Recommendation Report for Planning Permission for Works or Extension to a Dwelling

REF NO: P/36/22/HH

LOCATION: Sefter Cottage
Pagham Road
Pagham
PO21 3PX

PROPOSAL: Erection of two storey rear extension.

PROPOSED NORTH ELEVATION 1:50

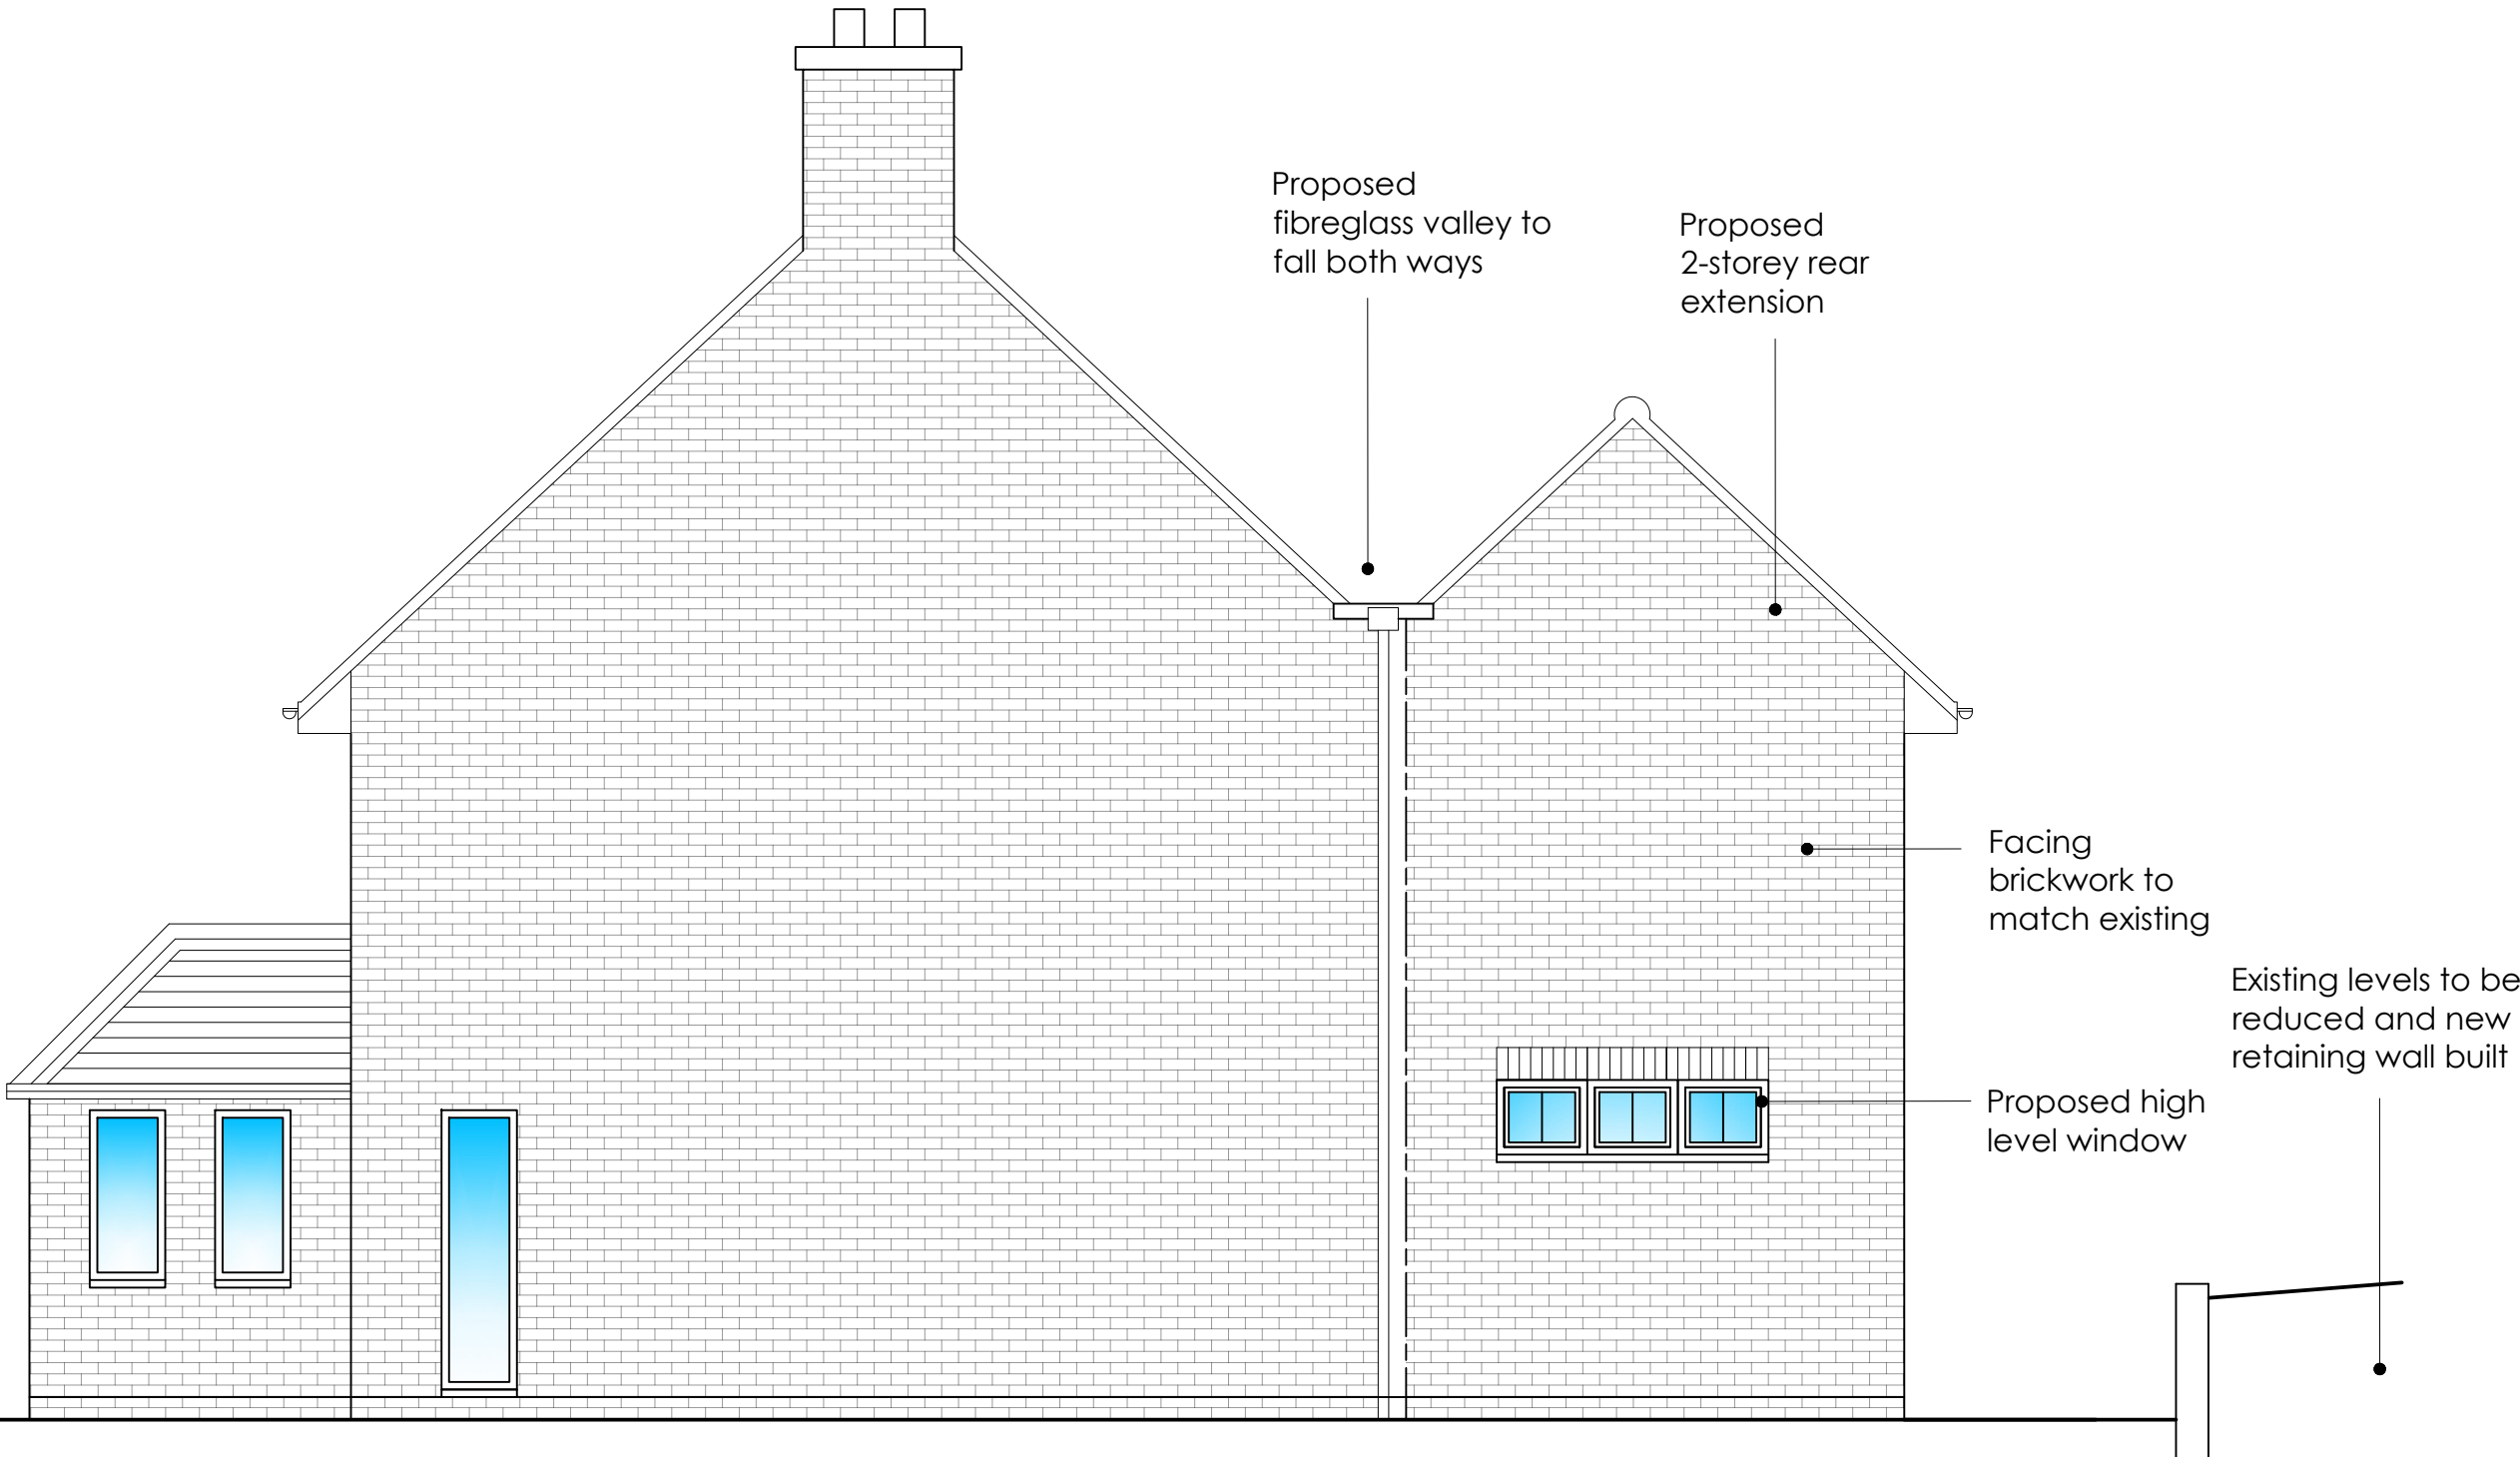
A loft conversion within the main roof of the host dwelling is also proposed. This will result in 3 rooflights being constructed to the front and rear. The works are likely permitted development and again due to the location of the property, will not result in adverse overlooking.

PROPOSED GROUND FLOOR PLAN 1:50

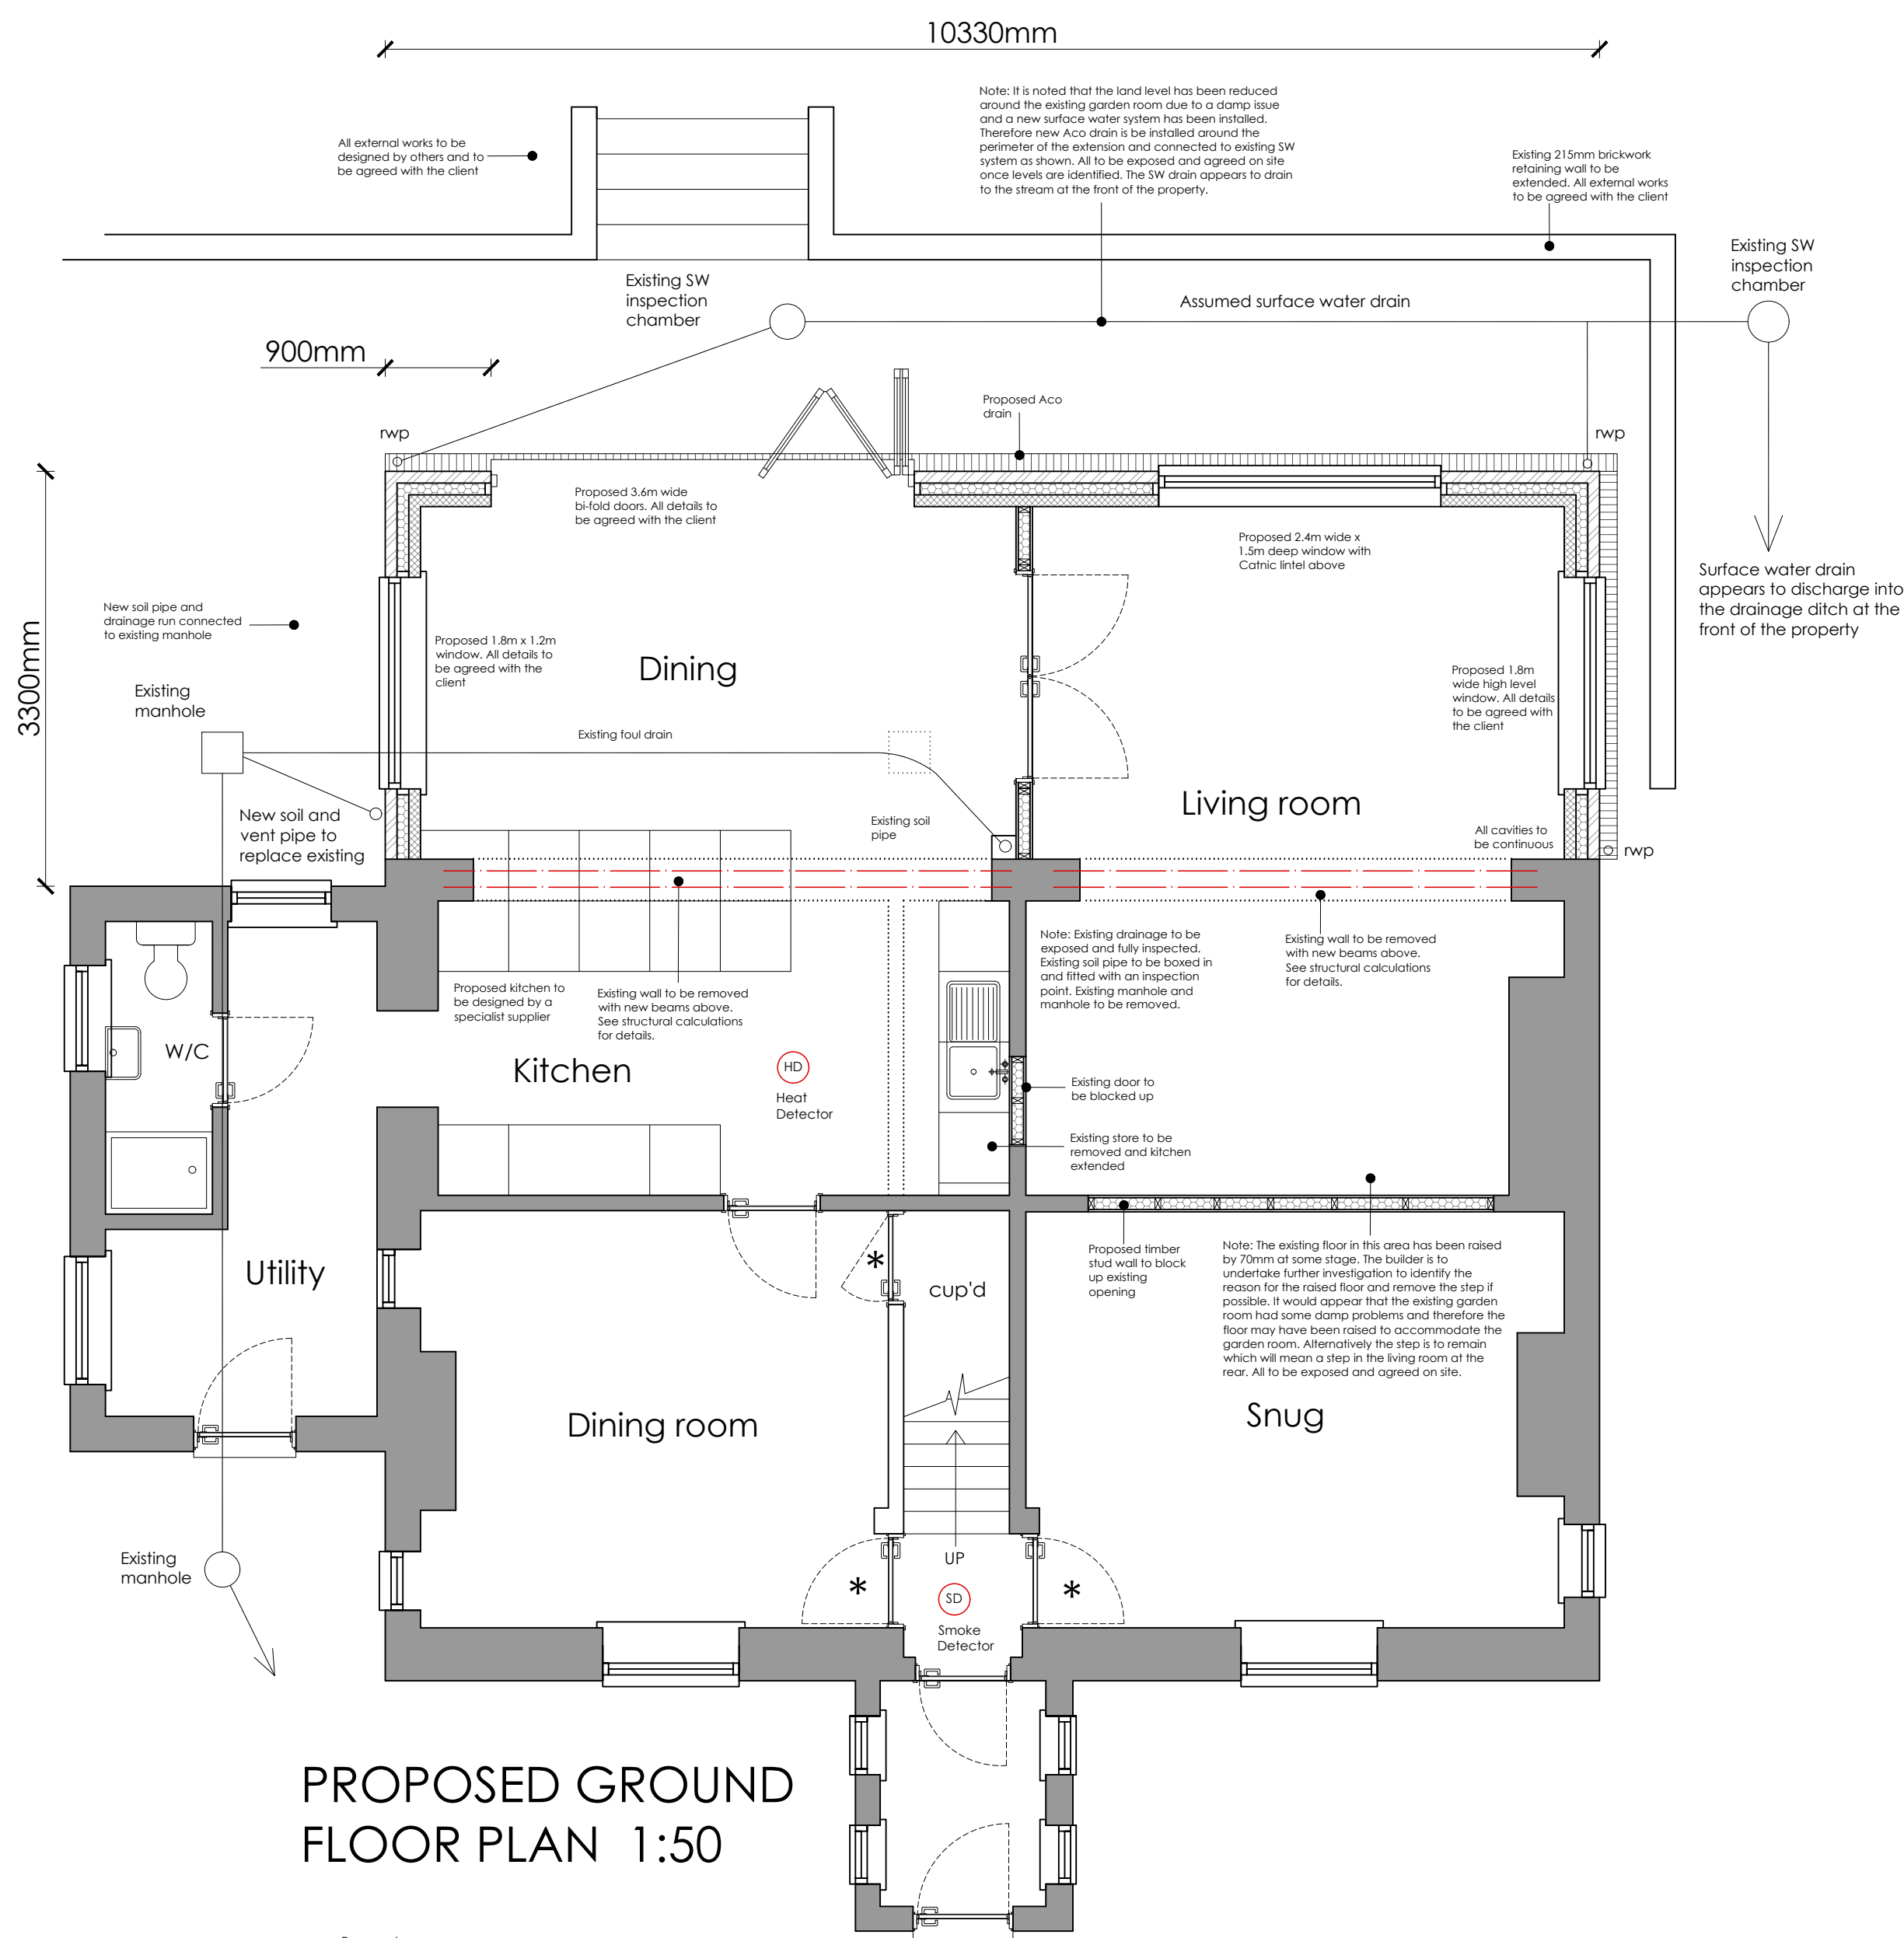
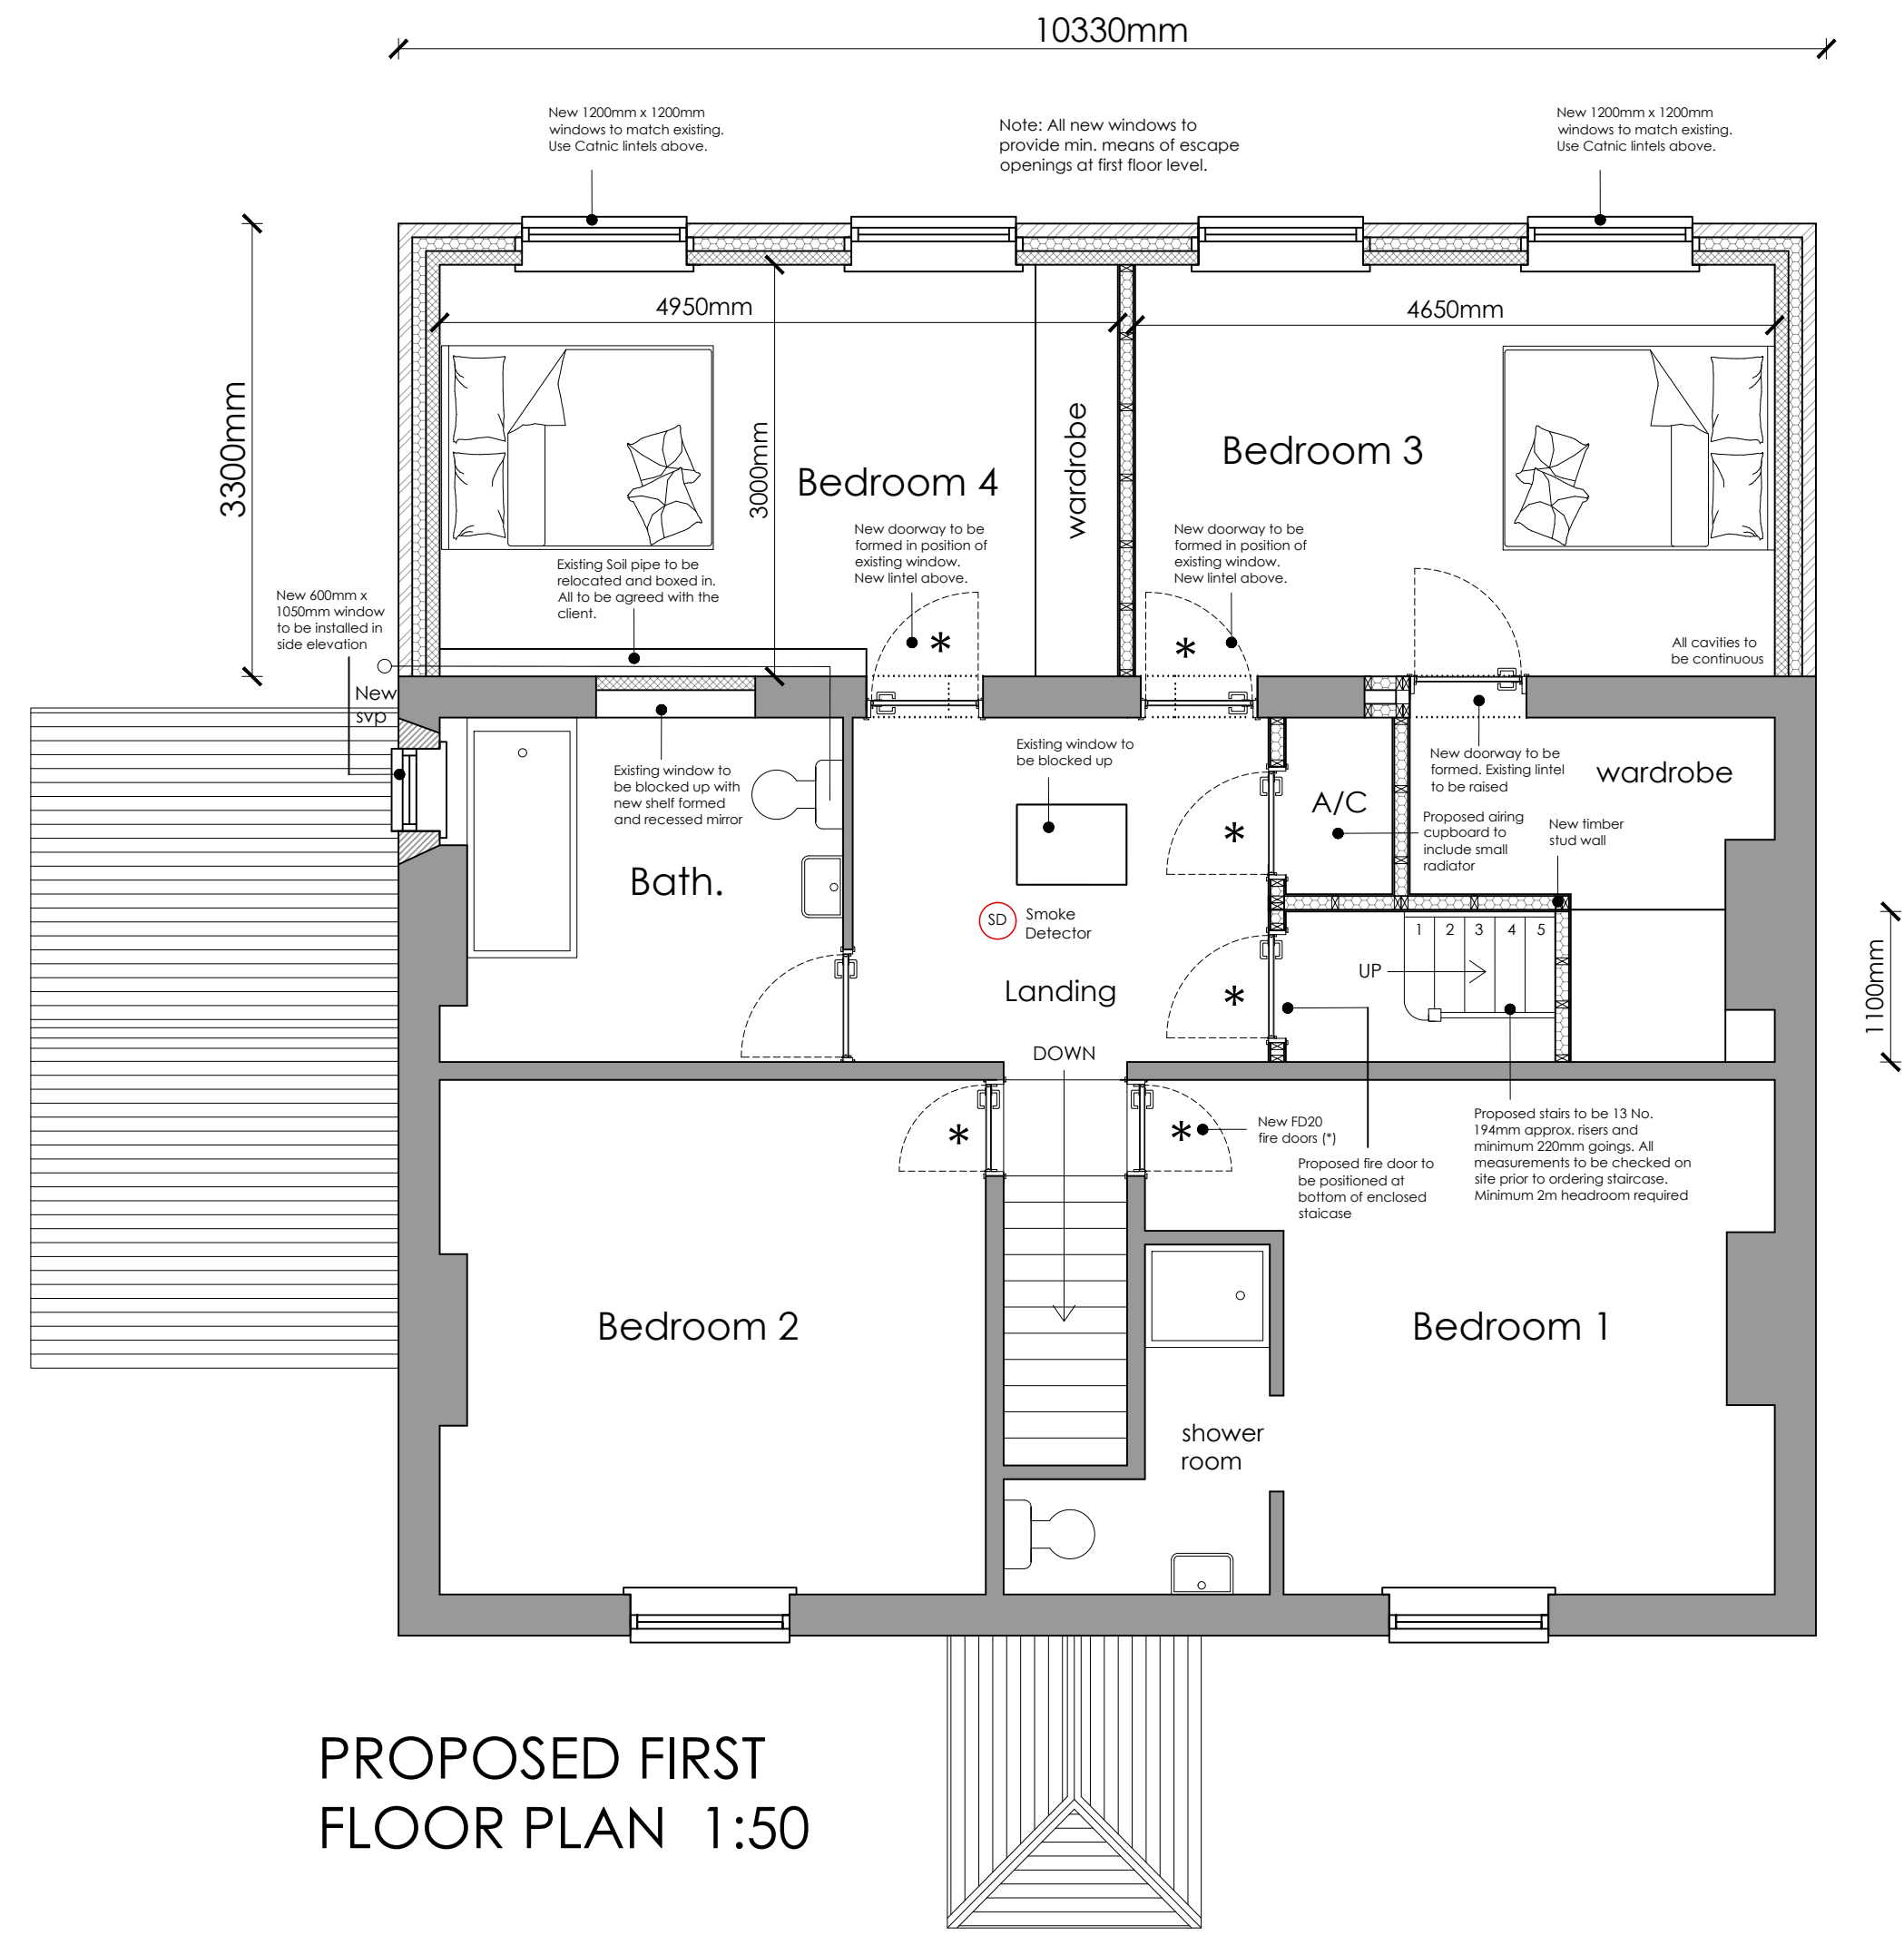
The dwelling is a detached two storey property with a single storey conservatory to the rear. The proposal will remove the conservatory and replace with a two storey extension that will run along the full rear elevation. Due to its siting, views are largely restricted from the wider area.

The extension will retain 12m to the rear boundary and 13.5m to the northern side. There are no neighbours to these elevations and the proposal will not result in harm upon these elevations.

2.3m is retained to the south western boundary. Rookery Cottage is located to the south although is located a sufficient distance away as not to result in adverse overbearing or overshadowing impacts.
